EXQ1 Q1.9.6

Potential Effects of XLPE Cables on Soil & Water Aquifers

Typical 33 kV Cable Trench Cross-section
(Example for 4 circuits, dimensions will vary)

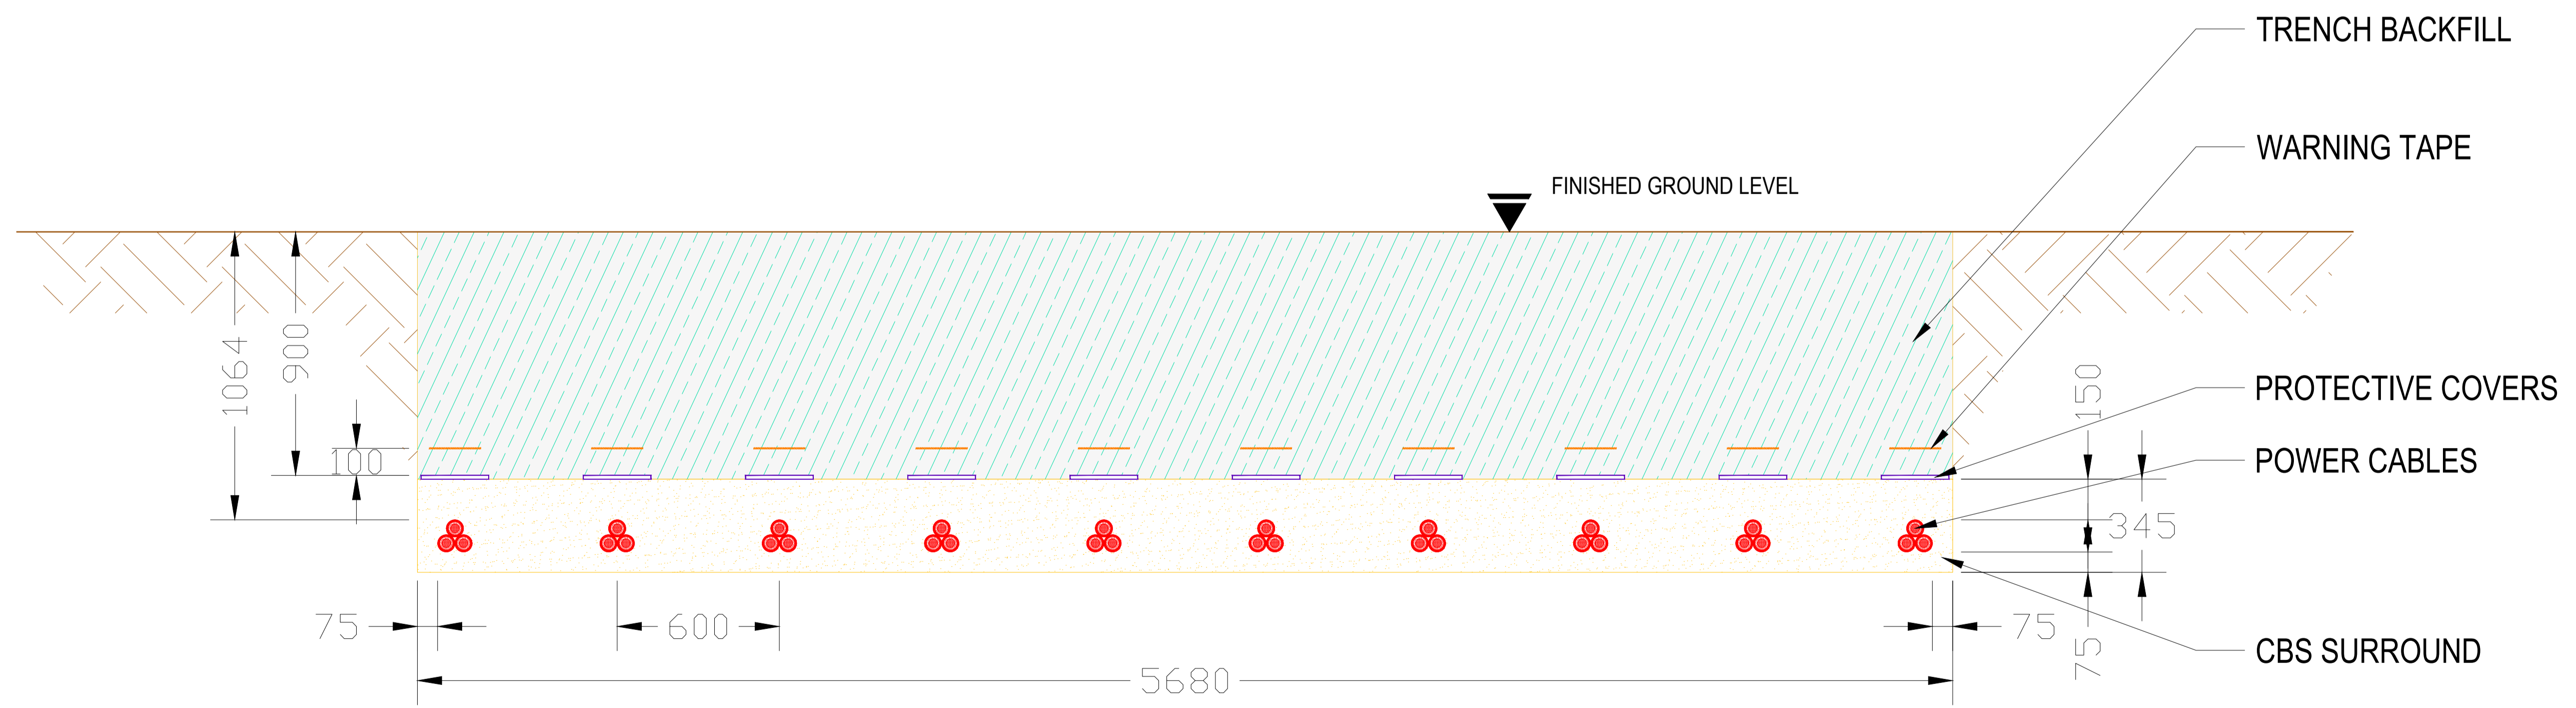
It is very clear from the application that there is going to be a significant amount of cabling buried across the site. The applicant has only proposed to remove surface-based material at the point of decommissioning. This will leave a huge amount of contamination underground. XLPE cabling has many potential contaminants, and this should not remain in the ground above a primary aquifer. We understand the applicants desire to only remove surfaced based material, this is cost calculation. It is the planning inspectorate's responsibility to ensure the applicant is not permitted to leave contamination below ground. No matter what the costs, it is the responsibility of the applicant to return this land to its previous state by removing all contamination even materials that were buried. What are the risks?

What standards are being implemented to ensure there is zero impact on the aquifer? Are any of the following actions being taken? Protective measures such as bentonite layers, encasement, or double sheathing to prevent leaching or intrusion.

1. Use of ducts or concrete encasement to prevent direct soil contact.
2. Laying impermeable barriers (like clay liners) to stop contaminant transport.
3. Installation of groundwater monitoring points to detect any changes post-installation.
4. Ensuring old or damaged XLPE cables are not left in-situ where degradation could occur.
